To: Jordan & Skala Engineers, Inc. RFI #: 66  
 14240 Midway Road, Suite 350 Date: 2/24/2012  
 Dallas, TX 75244 Job: EB-02 Keller Springs Lofts  
 Ph: 469/985-1616 Fax: 469/985-1615 Phone: 877-777-5115

Subject: HVAC requirements for elevator shaft

To: Erik Earnshaw RFI #: 134  
 Beeleer Guest Owens Architects Date: 5/30/2012  
 4245 N. Central Expressway Job: EB-02 Keller Springs Lofts  
 Suite 300 Phone: 877-777-5115  
 Dallas, TX 75205  
 Ph: 214/520-8878 Fax: 214/520-8879

Subject: Corridor duct issues

SHEET NUMBER  
**M-9.1**

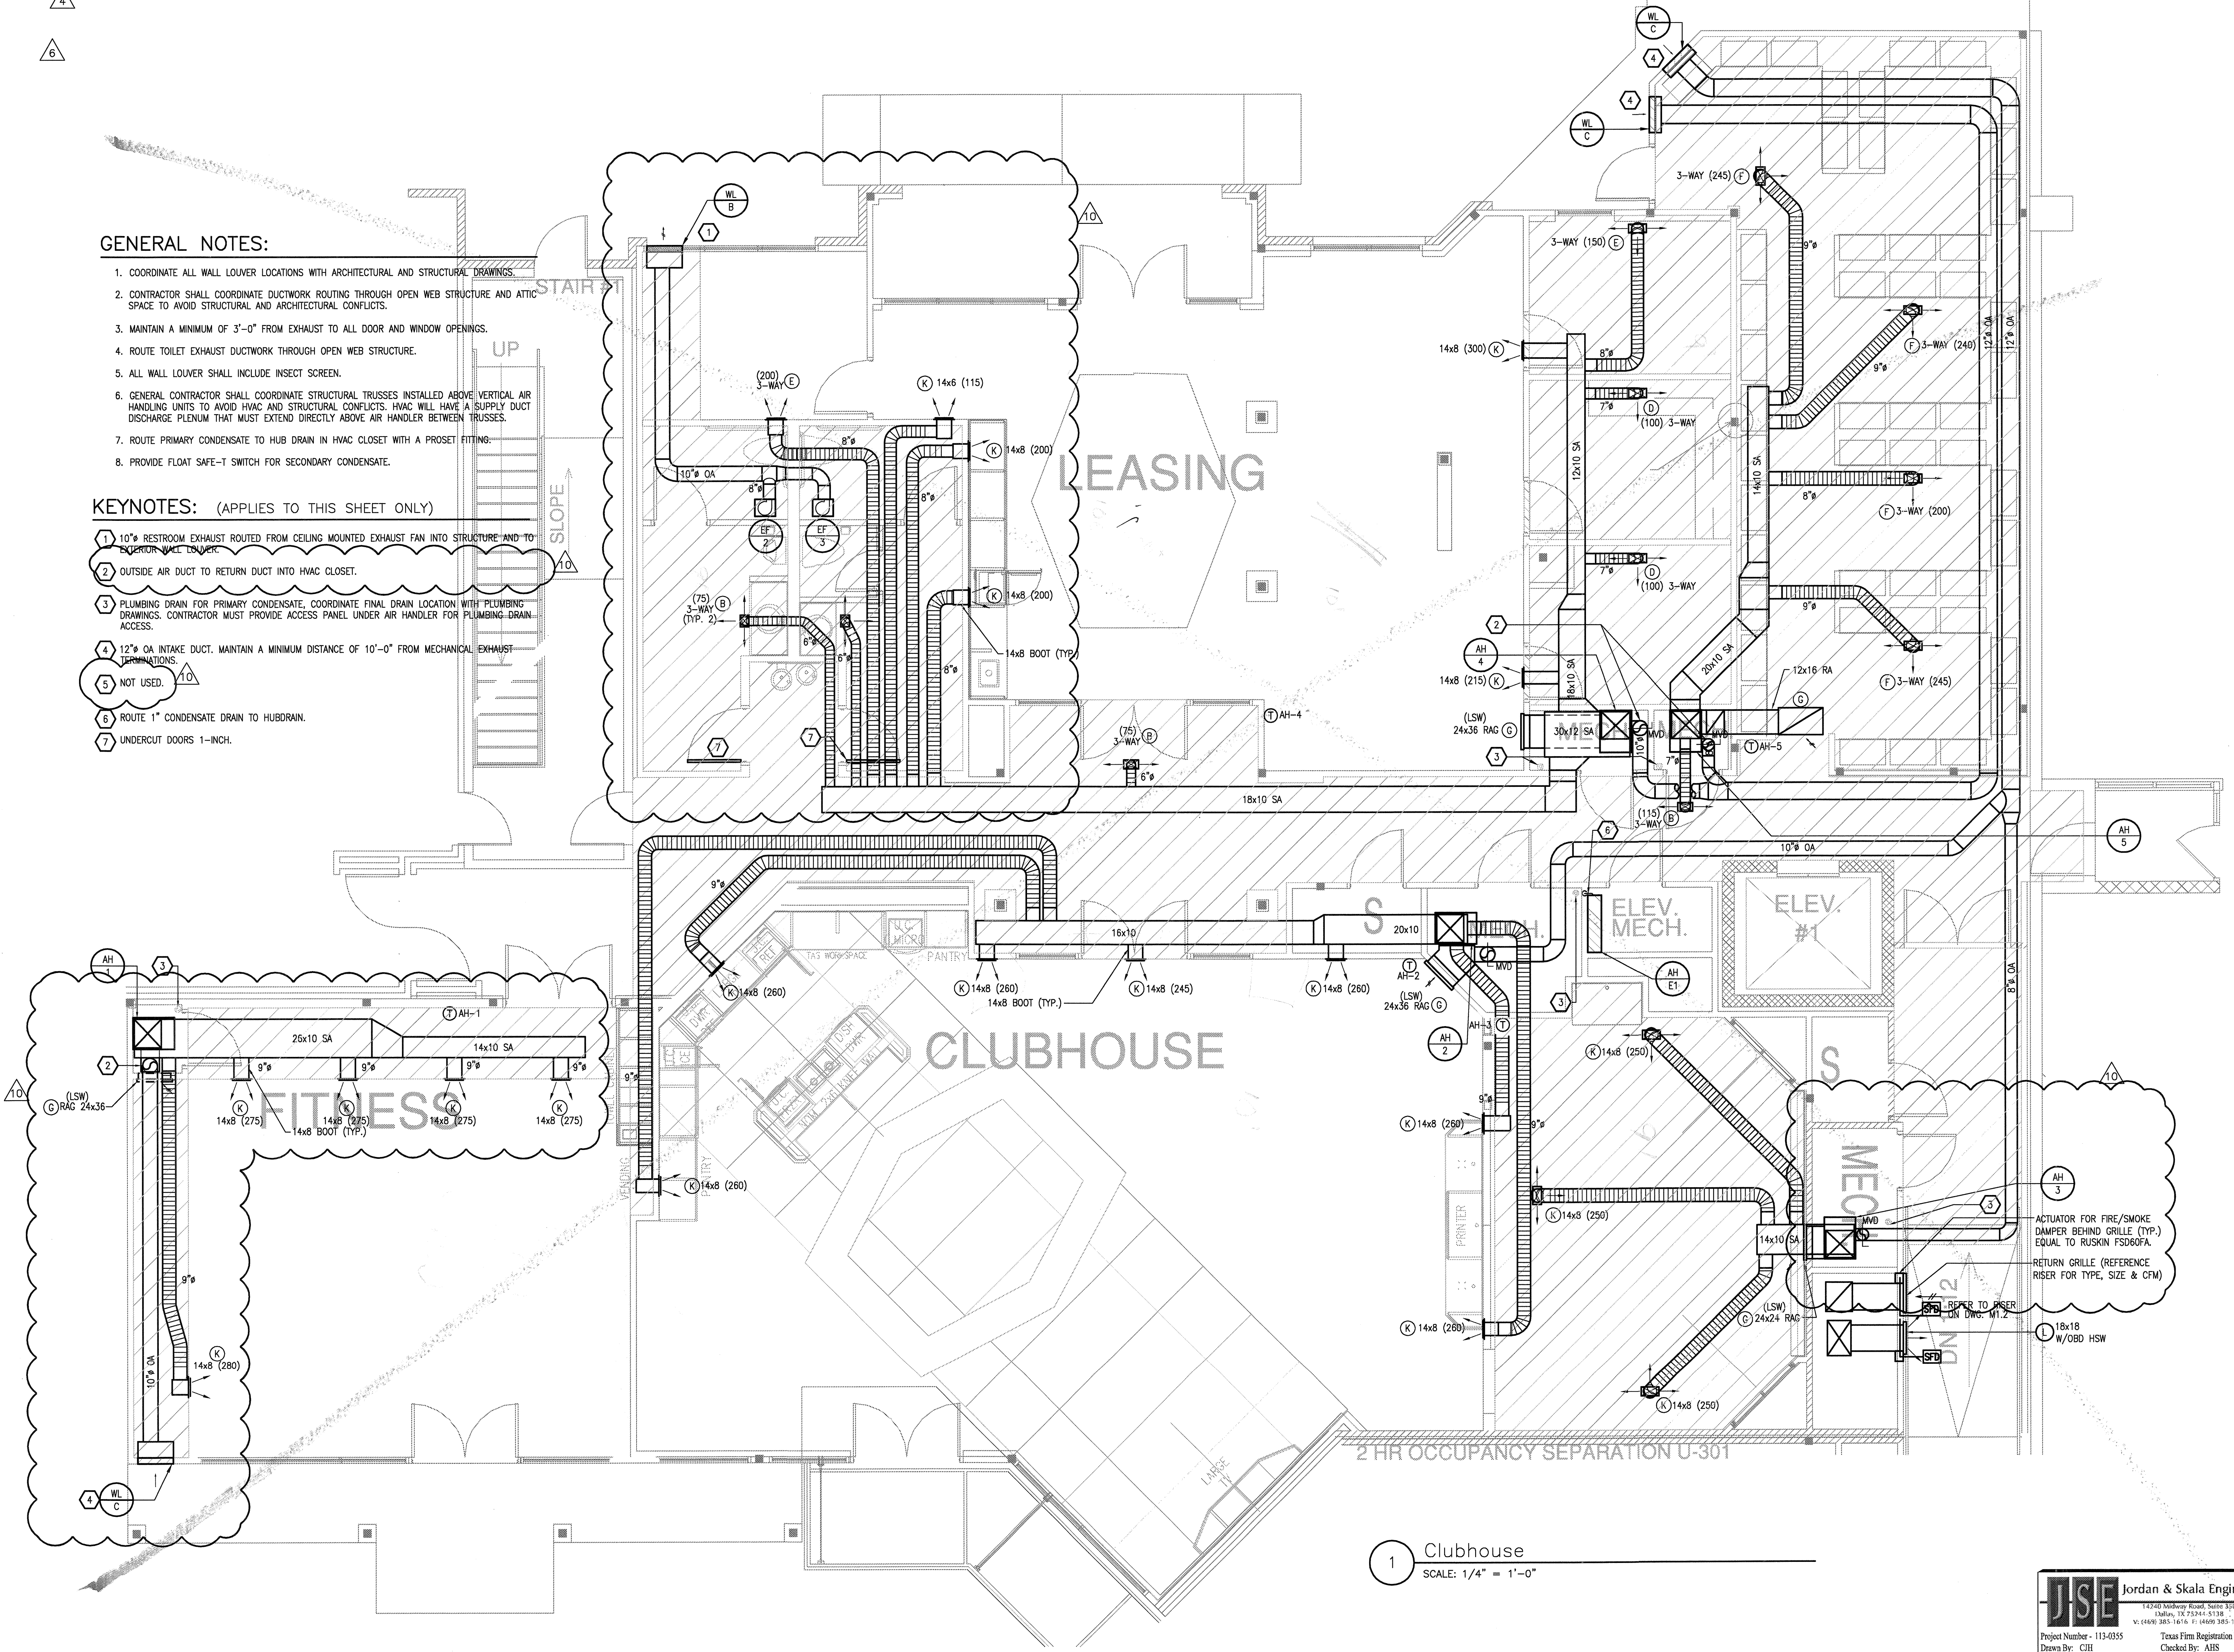
**Request:** Date Required: 3/2/2012  
 Heath below is a RFI requested by our HVAC subcontractor TDIndustries.  
 Bryan,  
 This morning, Jay Bitner with Schindler Elevator indicated that they would not be using the two rooms designated on the plans for elevator equipment (EMR) for their elevator machinery. The elevator machinery will actually be located in the elevator shaft. I have 2 questions:

1. Should we eliminate the two ductless split system for the two rooms designated EMR? These rooms are shown on sheets M-4.2, detail #4 and M-9.1.  
 2. Is there now a requirement for HVAC at the elevator shaft? See item #26 on the attached information supplied by Jay.  
 As a side note, Jay indicated that Schindler has installed several systems of this type and has not seen the shafts conditioned and has not seen a problem with over-heating. I mentioned that TDIndustries is installing HVAC in the shaft of a different project currently under construction. However, that elevator shaft is located in a parking garage, which may have necessitated the HVAC. Another elevator located within the building on the same project did not require HVAC. Since both of Keller Springs elevators are located within the building, I'm thinking that conditioning of the elevator shafts will not be necessary. However, I will defer to the others to make that determination.

**Response:**  
 1. HVAC may be removed from the elevator machine room.  
 2. Per Schindler's recommendations, HVAC to be added or not required for the elevator shaft.  
 Corey Hewitt  
 Answered by: Jordan & Skala Engineers Date: 2012-02-28  
 Company: Date:
